Subject: Response to Environmental Impact Statement for Horsley Drive Business Park Stage 2, Buildings 2 and 3 (SSD- 17161650)

Notice of Exhibition – Horsley Drive Business Park Stage 2 – Buildings 2 and 3 (SSD-17161650)

Re: Advice on Environmental Impact Statement (EIS) – Horsley Drive Business Park Stage 2 Buildings 2 & 3 (SSD-17161650)

RE: EIS Exhibition of SSD-17161650 - Hurlsey Drive Business Park Stage 2

LEGEND

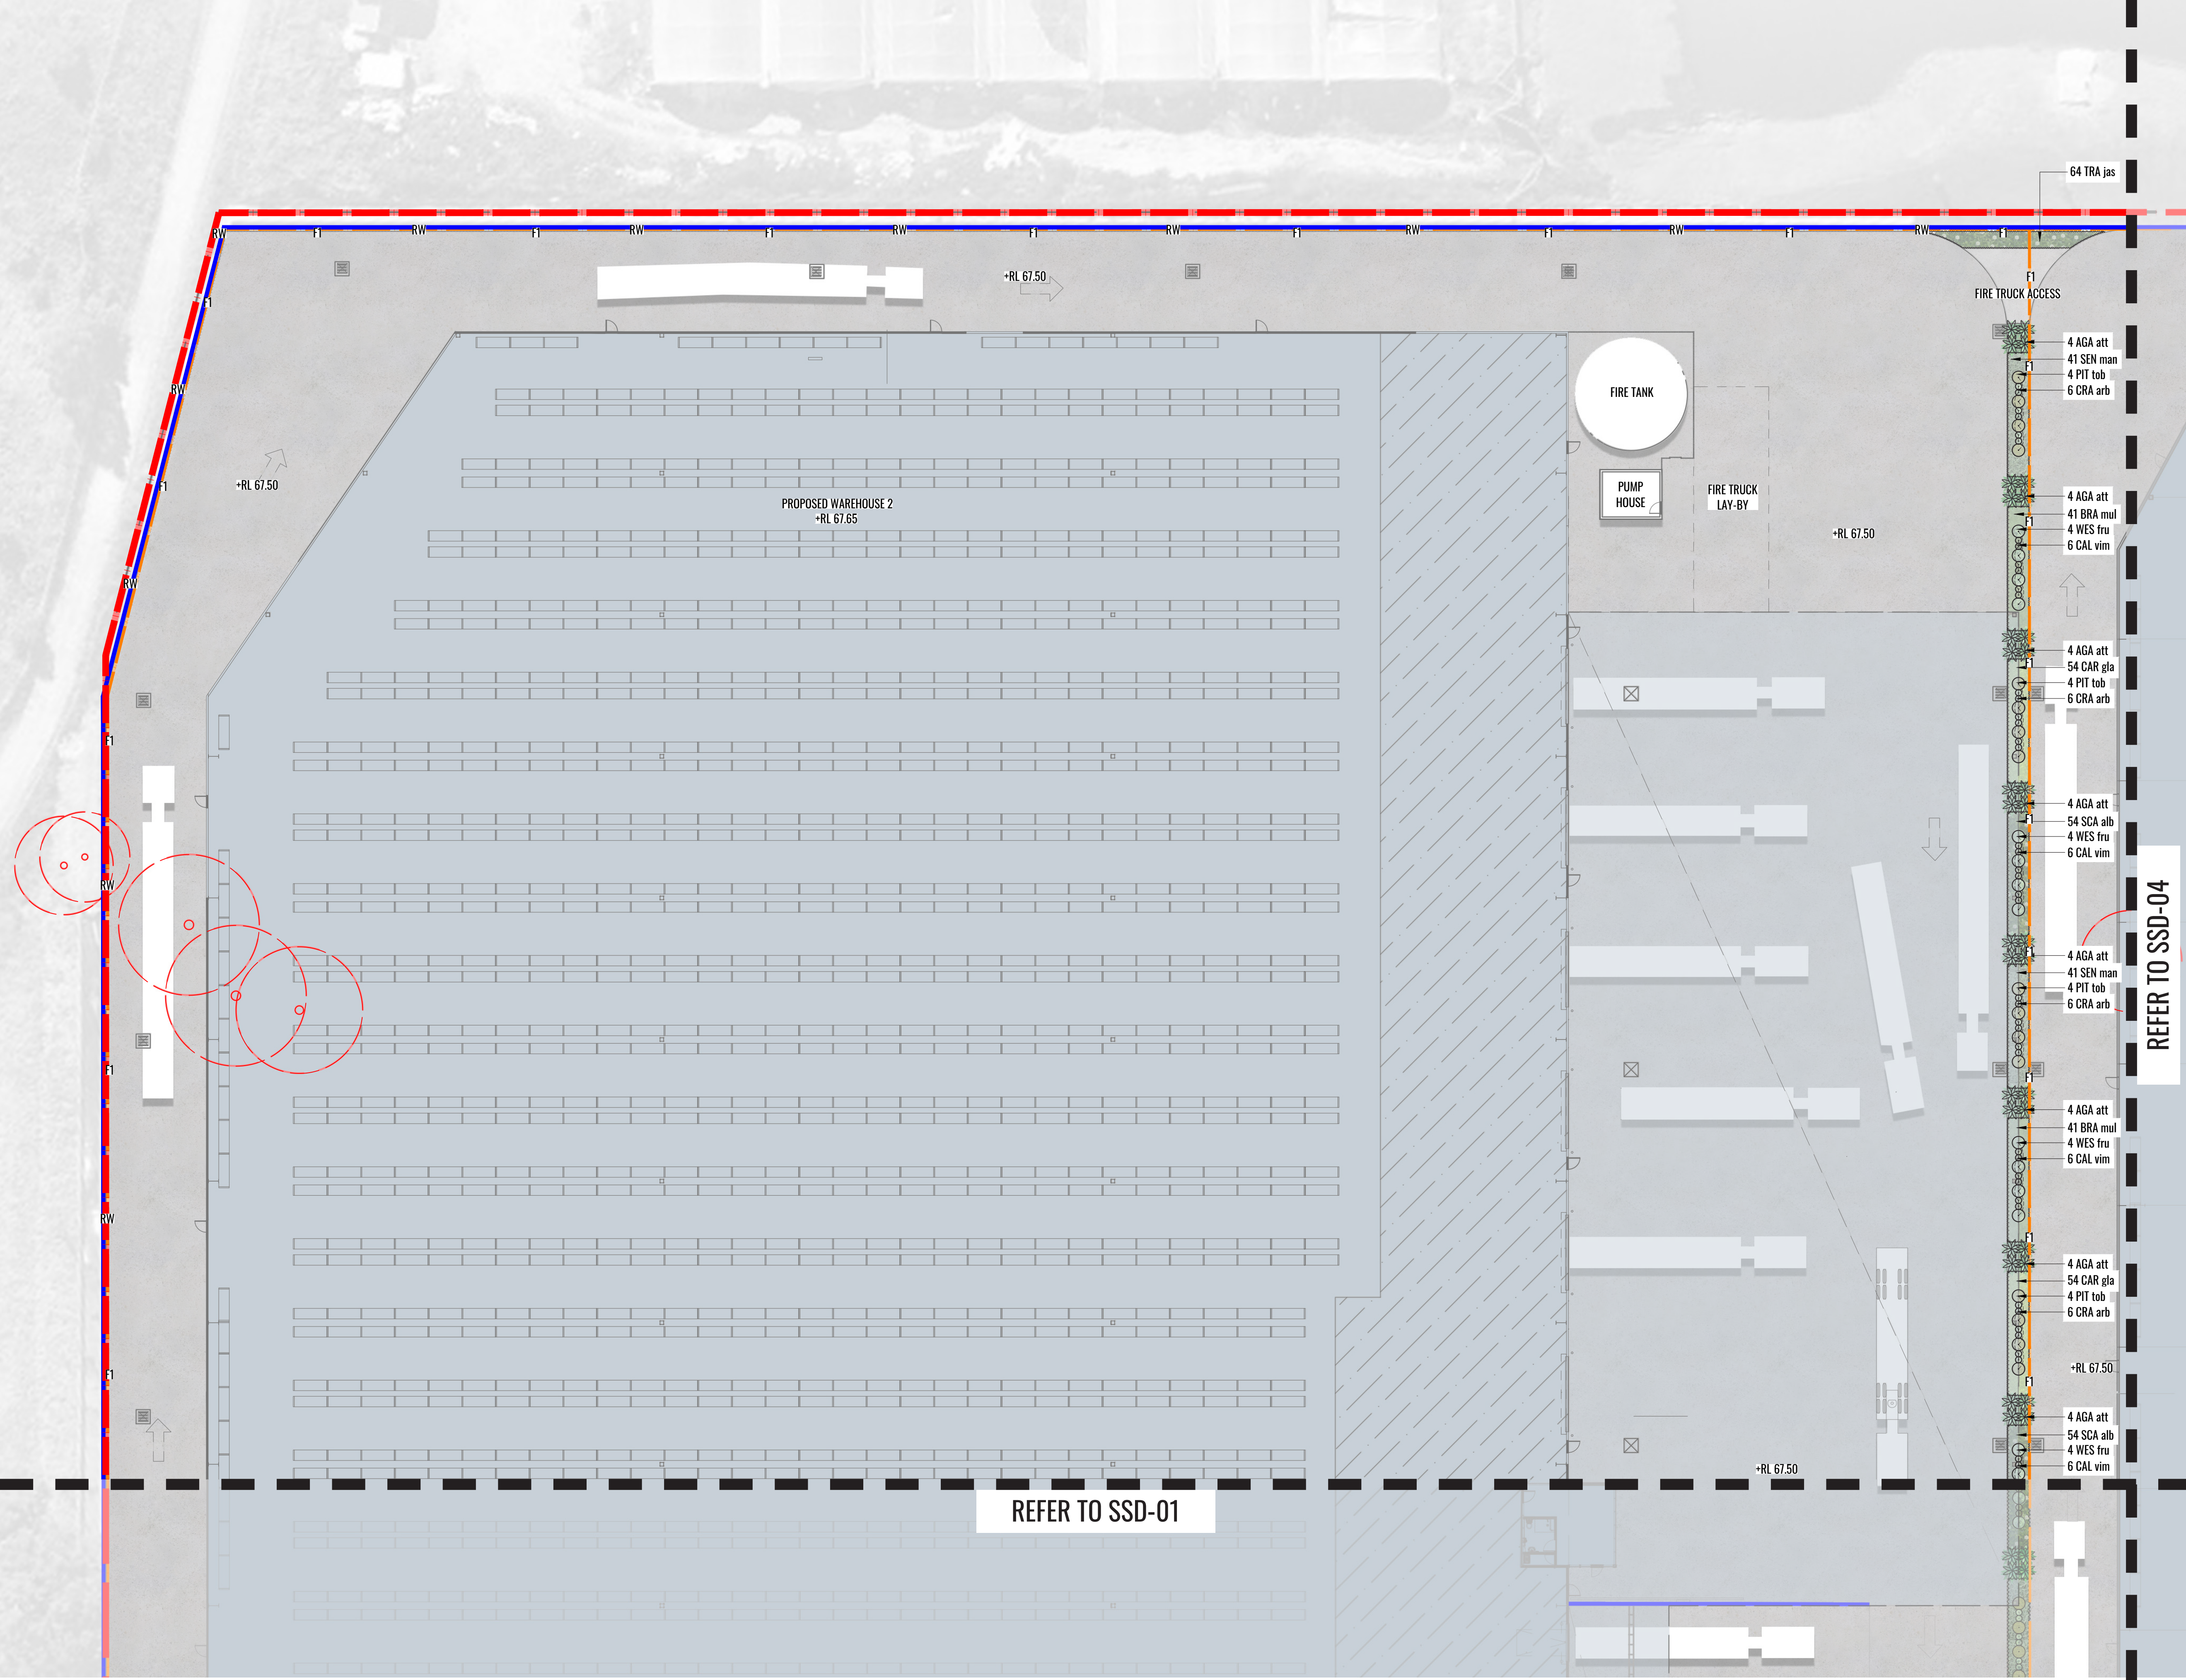
The proposed landscape plan only includes two species of medium to large trees (*Corymbia maculata* and *Brachychiton acerifolius*) or 9 trees total. A further 40 small to medium trees are proposed with 23 of these being *Tristaniopsis laurina*. Consideration should be given to increasing the number of medium - large trees in the proposed landscaping of the site. Increasing the setback of the driveway from the northern boundary and increasing the planting space would allow for additional planting along the boundary. Incorporating a planting bed along the western boundary would also provide an opportunity for further planting.

All trees proposed are specified with a 45L pot size. Minimum pot sizes for trees should be increased to 100L where possible, particularly for slow growing species such as *Tristaniopsis laurina*.
